**KIRKLEES METROPOLITAN COUNCIL
INVESTMENT & REGENERATION SERVICE**

DELEGATED DECISION TO DETERMINE PLANNING APPLICATIONS

Reference No:	2023/62/93083/W
Site Address:	adj, 33, Arthur Street, Golcar, Huddersfield, HD7 4DF
Description:	Demolition of detached garage and erection of 1 no. detached dwelling, formation of car parking spaces and access, associated landscaping, reconfiguration of parking spaces and access for existing dwelling
Recommending Officer:	Katie Chew

Officer Report

Northern Elevation 1: 100

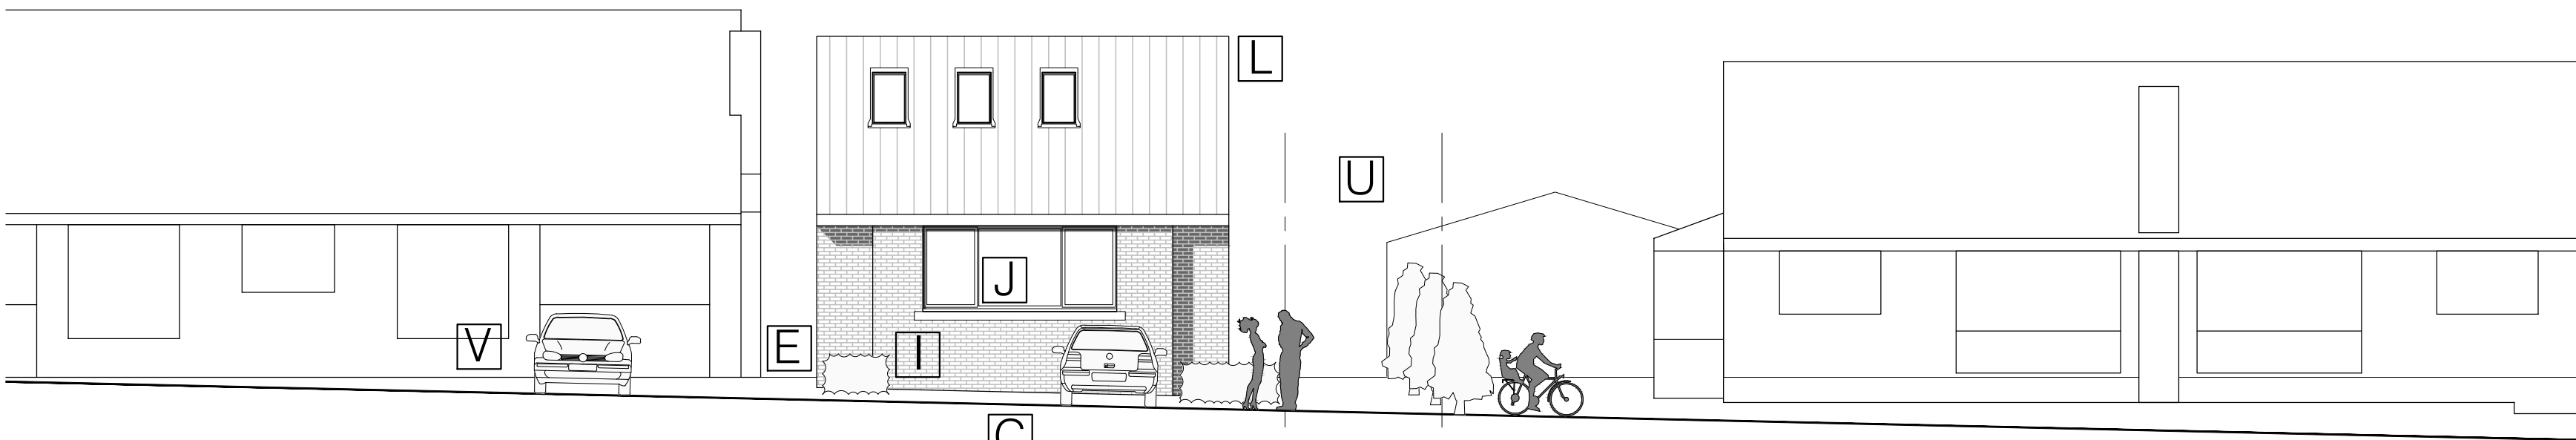
This neighbouring property is located to the north of the application site, approximately 9.7m away. Whilst it is acknowledged that 2 windows are proposed within the northern elevation of the new dwelling, these windows relate to non-habitable rooms but given their orientation looking towards a habitable room window within the southern elevation of no. 35, it is considered reasonable to include a condition which requires these windows to be obscurely glazed in the interests of residential amenity. Furthermore, Given the large separation distances, Officers have no concerns in respect of overshadowing. Finally, the proposed dwelling is to be single storey in height (utilising the roof space), this coupled with the large separation distances is considered to be sufficient to ensure that the proposals would not appear overbearing or overly dominant on no. 35 in this instance.

6. The windows within the northern elevation of the dwelling hereby approved, to serve the downstairs W.C and upstairs en-suite, shall be first fitted with obscure glazing minimum grade 4. Notwithstanding the provisions of Section 55(2)(a)(ii) of the Town and Country Planning Act 1990 and the Town and Country Planning (General Permitted Development) (England) Order 2015 (or any Order revoking or re-enacting that Order with or without modification), the windows shall thereafter be so retained in obscure glazing.

Block Plan 1: 200

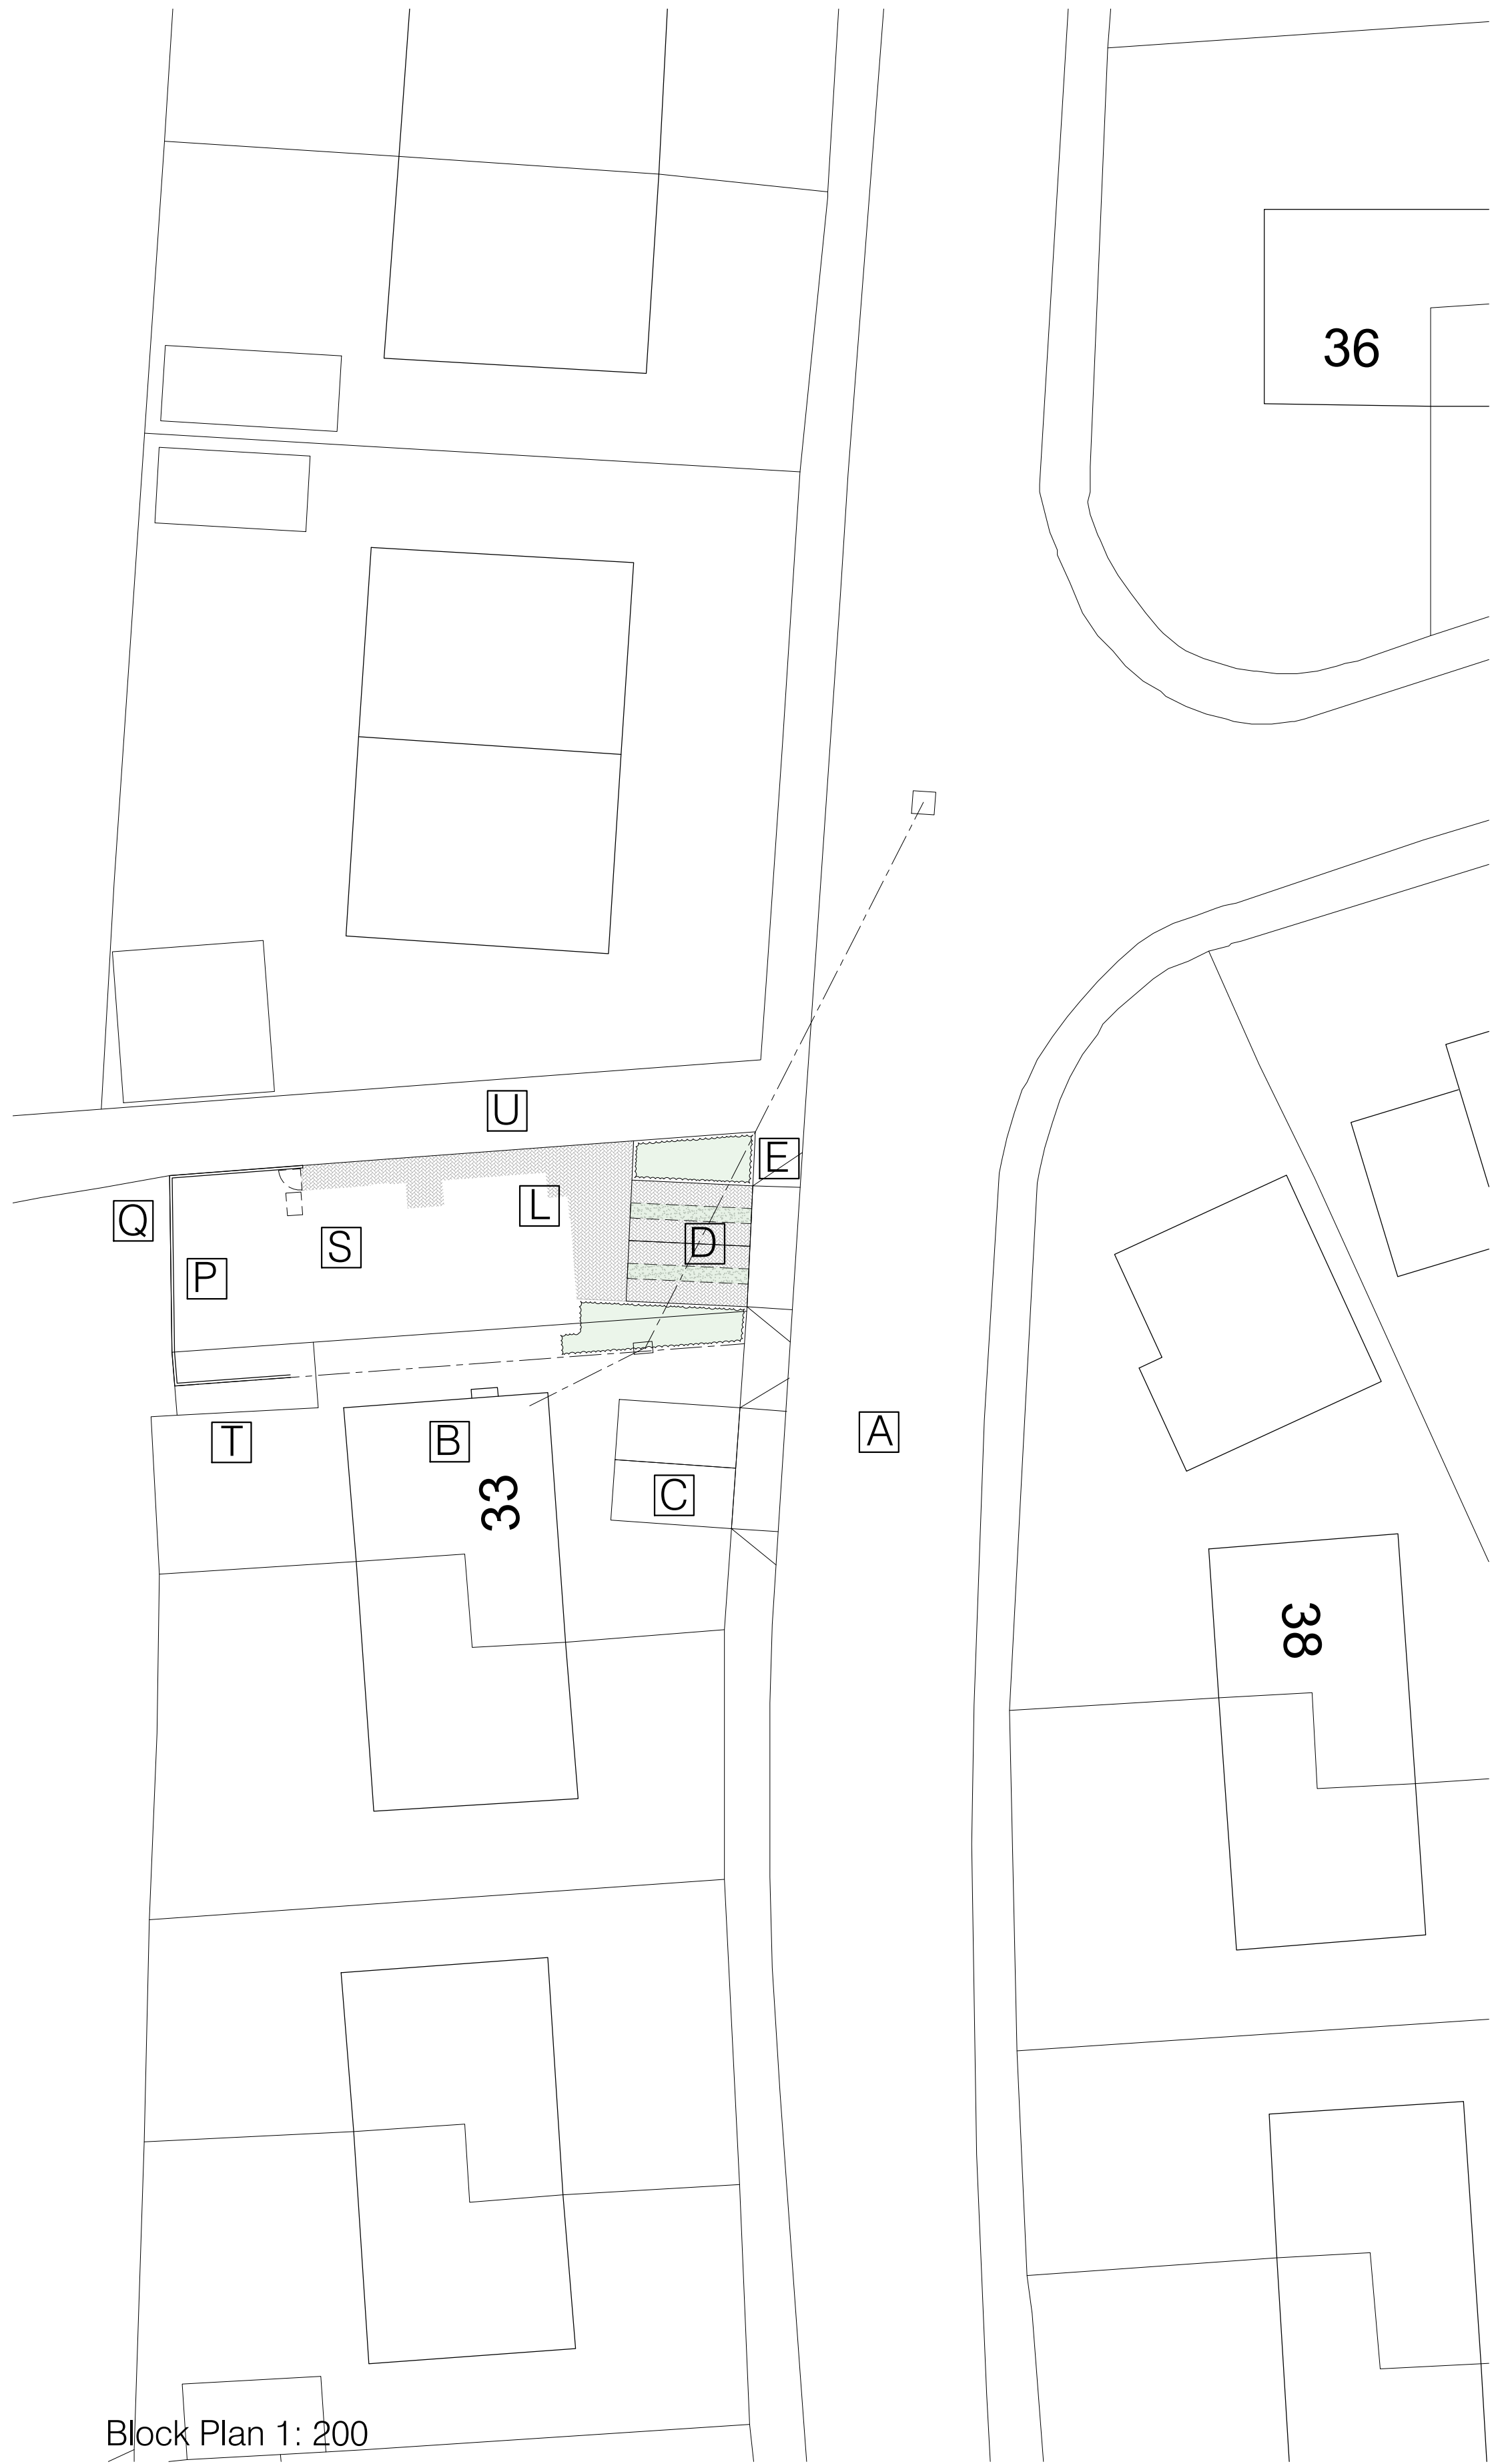
Amendments were sought following comments received from Yorkshire Water, who had concerns in respect of the planting proposed which would be sited over the public sewerage system and that this could seriously jeopardise Yorkshire Water's ability to maintain the public sewerage network. The applicant sought to submit amended plans outlining the location of the sewer and removal of planting from this part of the site.

Yorkshire Water – Comments received 1st November 2023. Object to the proposals as the development layout currently shown outlines that a tree/s will be sited over the public sewerage system and that this could seriously jeopardise Yorkshire Water's ability to maintain the public sewerage network.

Officer note: Following receipt of the above comments, the applicant's agent sought to submit amended plans which removes the proposed tree from the site layout plan. Yorkshire Water were again re-consulted and noted that they have no objections. Conditions are recommended, these are assessed in the report below.
